From: [Downes, Scott G \(DFW\)](#)
To: [Jeremiah Cromie](#); [Kelee Hodges](#); [Samantha Cox](#); [Torrey, Elizabeth M \(DFW\)](#); [DNR RE AQ LEASING RIVERS](#); [Warthen, Luke \(DNR\)](#); [MAUNEY, MARTY \(DNR\)](#)
Subject: RE: SX-22-00019 Jenkins - Request for comment
Date: Friday, October 14, 2022 4:35:12 PM

Subject: SX-22-00019 Jenkins - Request for comment

Please review the Shoreline Exemption Permit applied for by Jody Joldersma & Matthew Jenkins for an emergency temporary erosion control measures including root wads and rocks in Gold Creek to prevent further erosion to an existing house. As this is being applied for under an emergency shoreline exemption and emergency SEPA, please have all comments back to me no later than **5p October 14, 2022**. Links to the file materials can be found below. If you believe other people/agencies need to be included please let me know ASAP.

2022 Proposed Plan
(Pin down root wads with large rocks along shore toe then reassess and follow up next year)

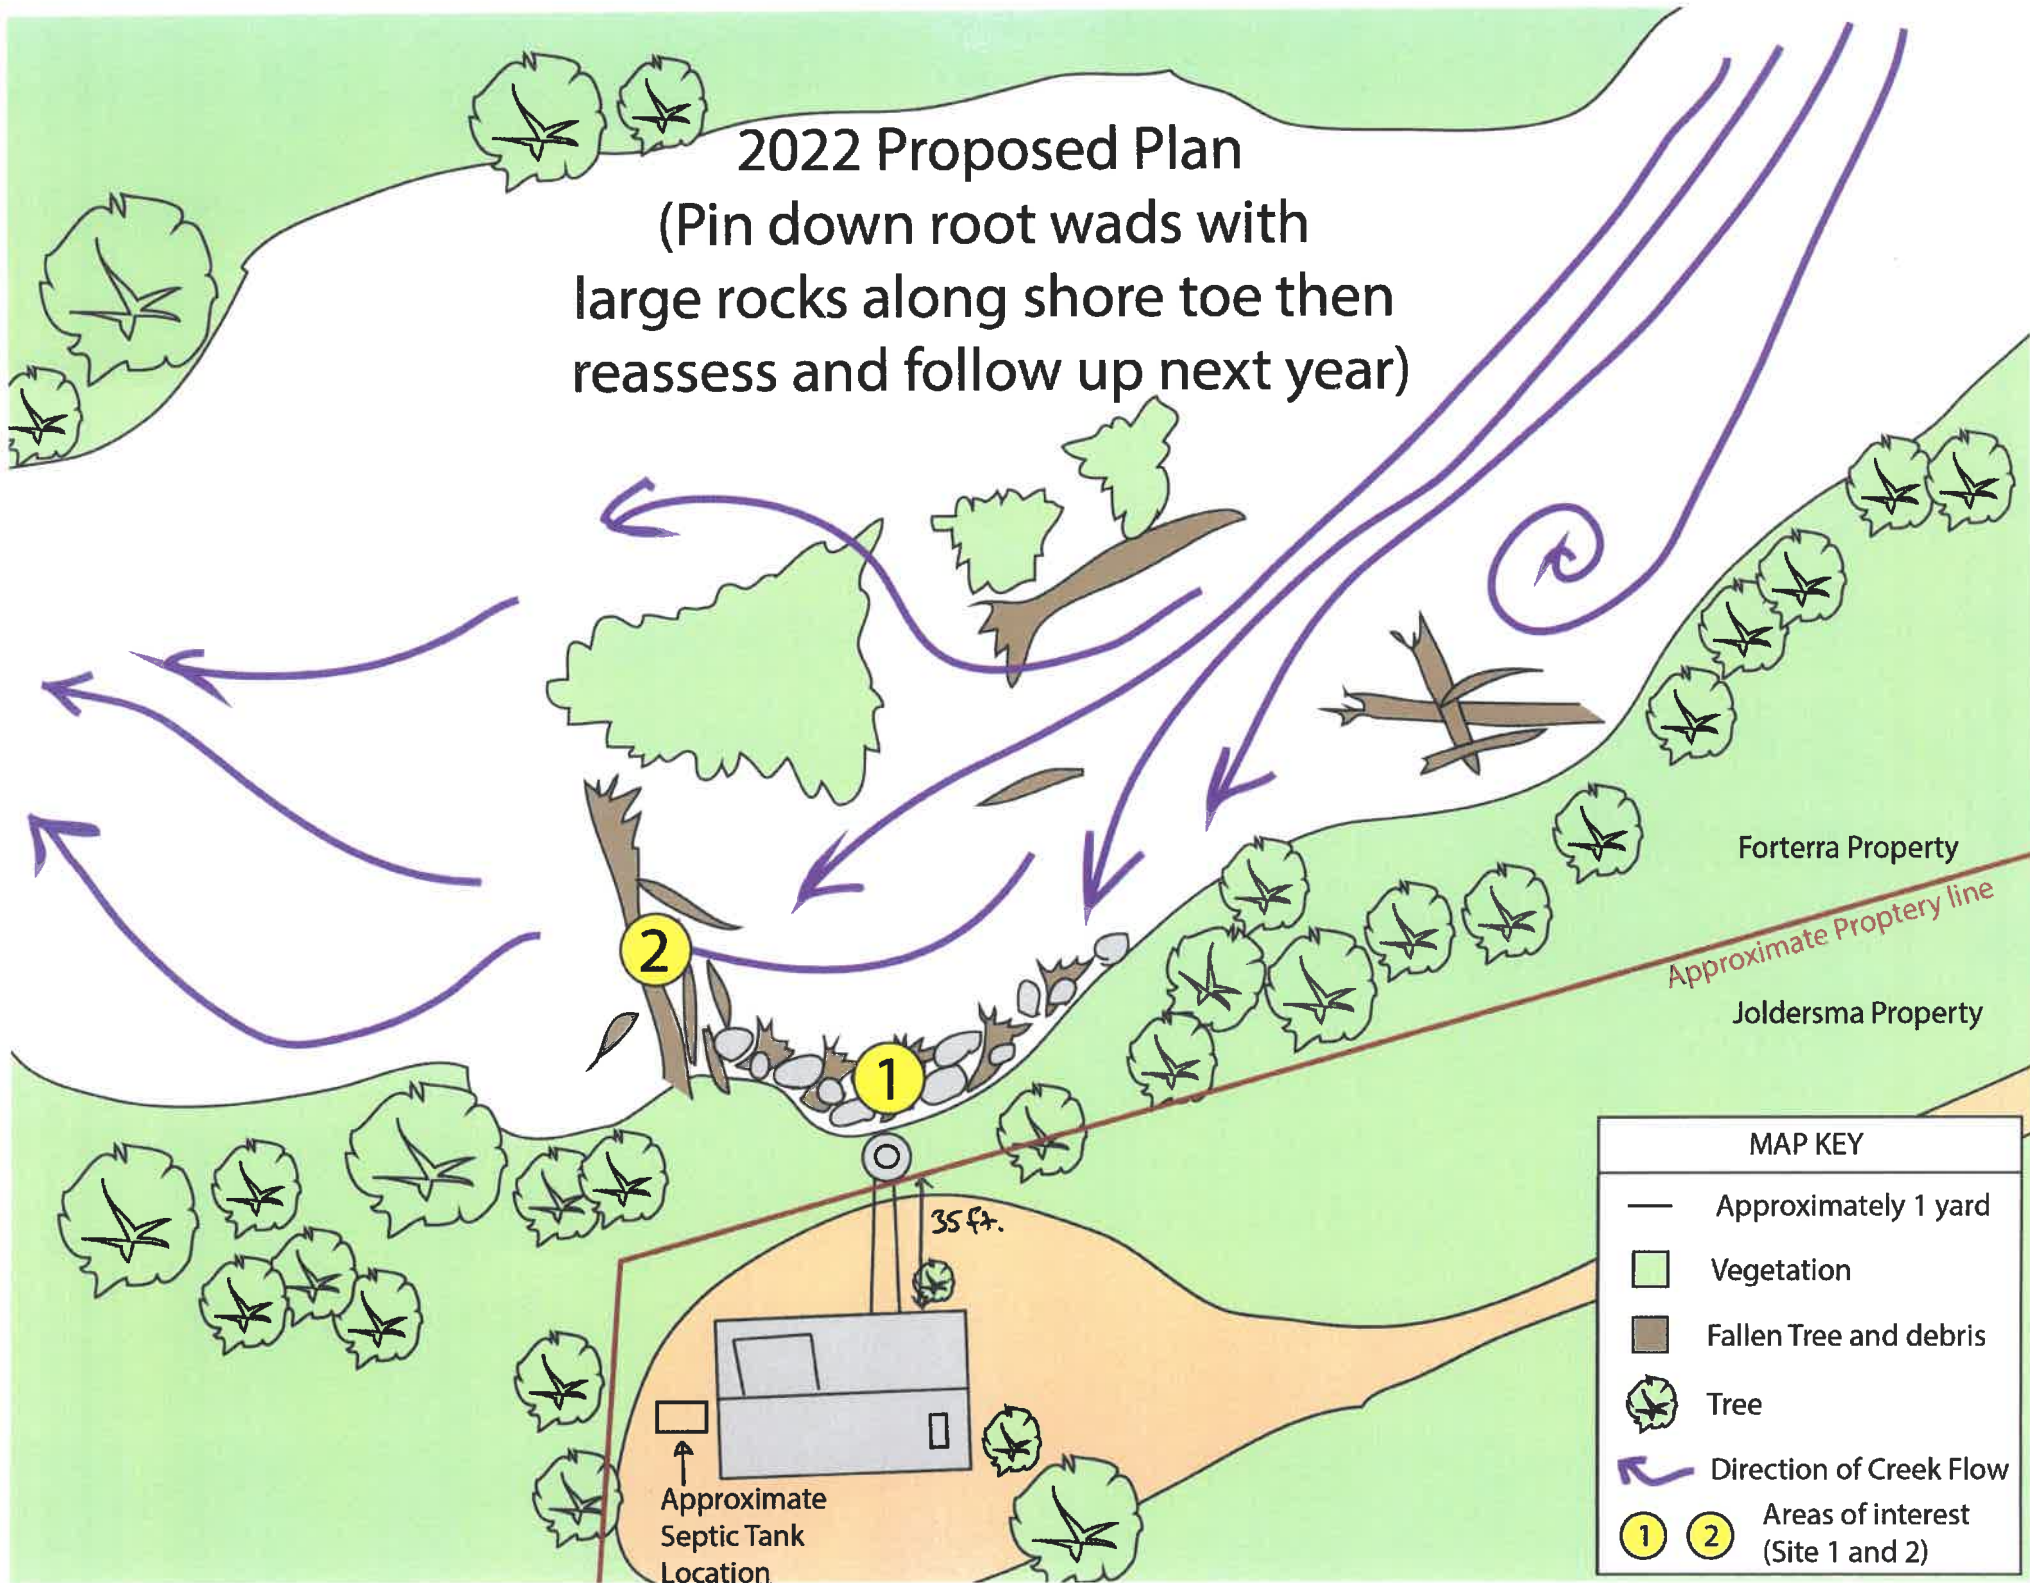
As for resources at the site in addition to ESA listed Bull Trout habitat, the property is also in both floodplain and Channel Migration Zone and any designs should be designed so as to not compromise the function of either.
